Report of the Head of Planning, Sport and Green Spaces

Address 23 MINET DRIVE HAYES

Development: Single storey detached outbuilding to rear for use as a shed (Application for a Certificate of Lawful Development for a Proposed Development)

LBH Ref Nos: **25274/APP/2014/1911**

Proposed Ground Floor Plan

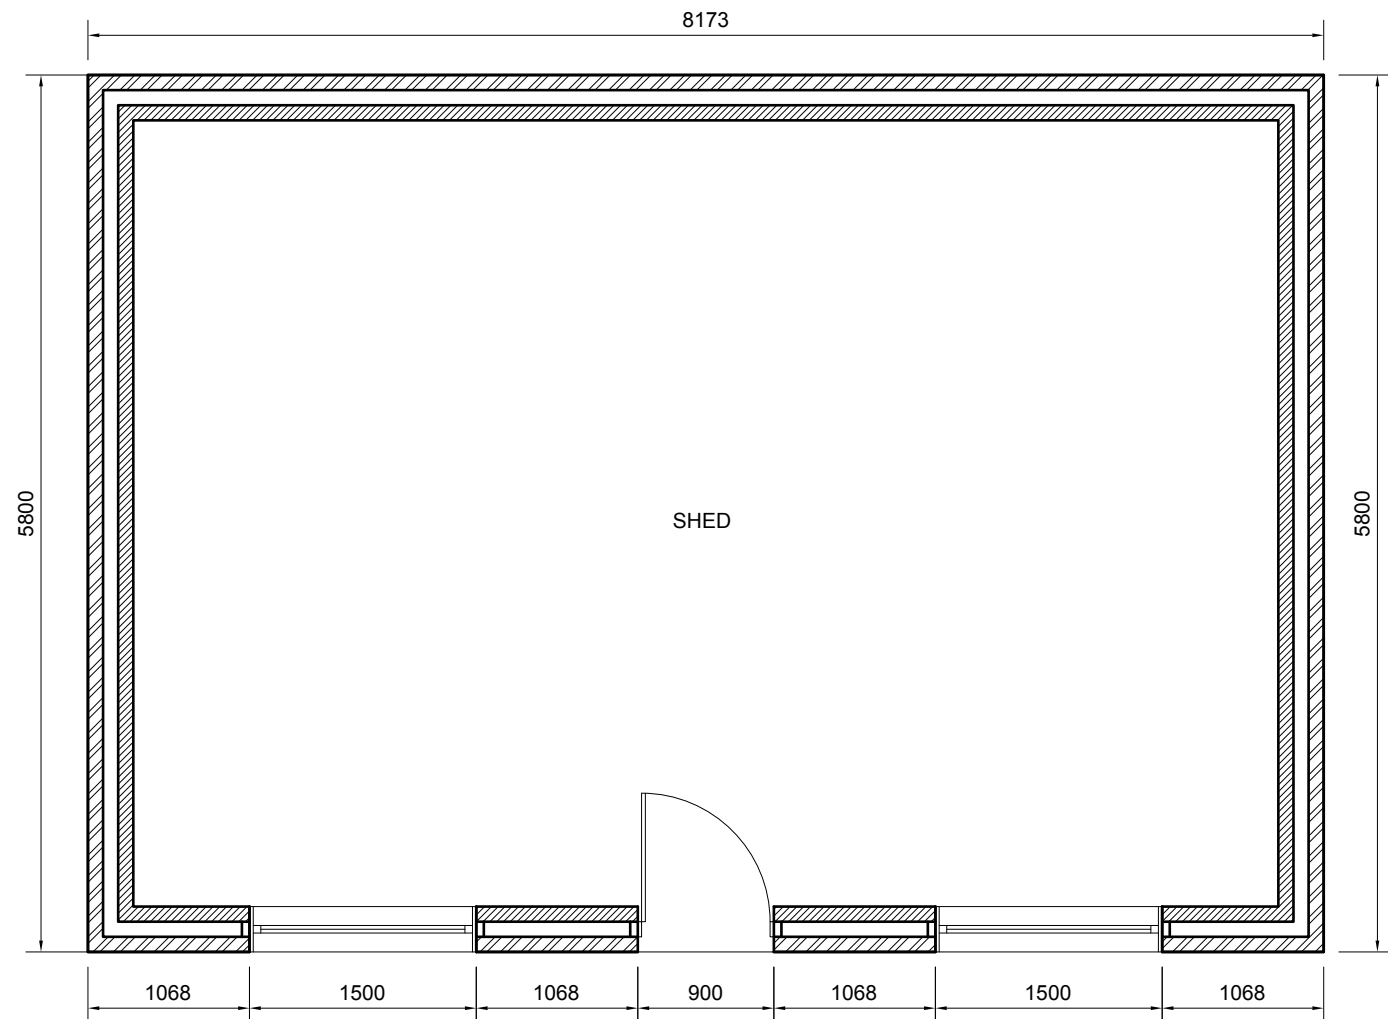
However at a footprint of some 47.56m², the proposed outbuilding would represent marginally over 100% of the footprint of the original dwellinghouse. This is considered to not represent a development 'for a purpose incidental to the enjoyment of the dwellinghouse' as the scale and appearance would not be commensurate to the size of an ancillary structure.

In relation to this particular site it is considered the proposed size of the building (at 47.56m²) is excessive, and would exceed the footprint of the original house (47m²). It is considered due to the proposed size of the building it would not be considered subordinate/incidental but rather form the primary use on the site.

In view of the size and scale of the outbuilding, the proposed building is considered to not represent a development which is reasonable required 'for a purpose incidental to the enjoyment of the dwellinghouse' as the building would be of a scale and appearance which would not be commensurate to the scale of an ancillary structure.

That a certificate of lawful use or development be **REFUSED** for the proposed development described above in respect of the land edged red on the attached plans for the following reasons:

The proposed development does not constitute permitted development by virtue of the provisions of Schedule 2, Part 1, Class E of the Town and Country Planning (General Permitted Development) Order 1995 as amended by the Town and Country Planning (General Permitted Development) (Amendment) (No2) (England) Order 2008 as the proposed building, by reason of its overall size and scale, is considered not to represent a development required for a purpose incidental to the enjoyment of the dwellinghouse.
